Application for a Non-Material Amendment Following a Grant of Planning Permission

Proposed creation of a dormer with Juliet balcony and windows; small side extension to annex; replacement patio-covered structure; new garage; covered timber deck (revised scheme)

23/00191/HOU

To move the Lower Ground floor lounge door position slightly.

Drawing No. **231/PL16** Rev.F

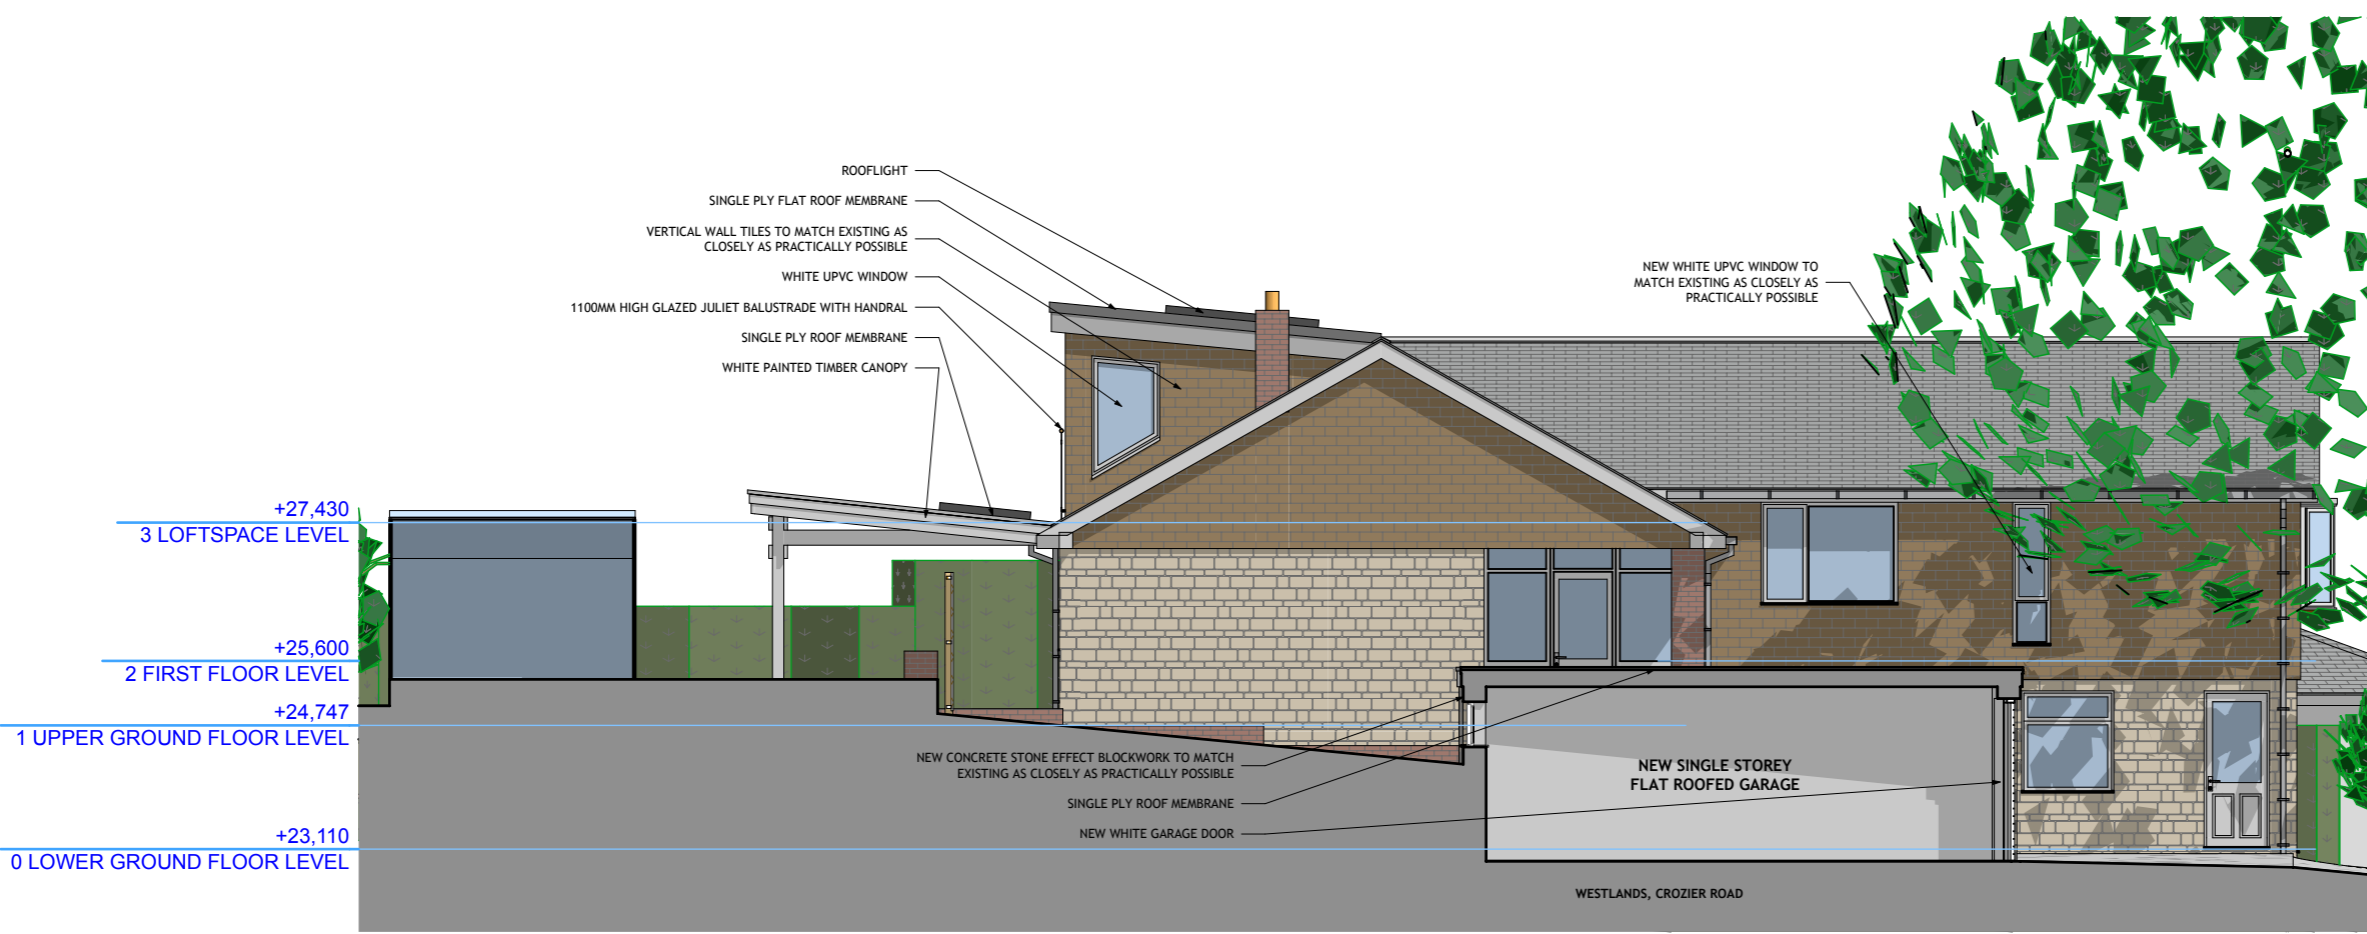
Client has requested the Lower Ground floor lounge door position to be moved slightly to allow entry to come in behind lounge sofa area and not in the middle of it.

231 PL04 REV C EXISTING LOWER GROUND FLOOR PLAN _ Layout.pdf
231 PL12 REV H PROPOSED LOWER GROUND FLOOR PLAN _ Layout.pdf
231 PL16 REV F PROPOSED FRONT AND LEFT SIDE ELEVATIONS _ Layout.pdf
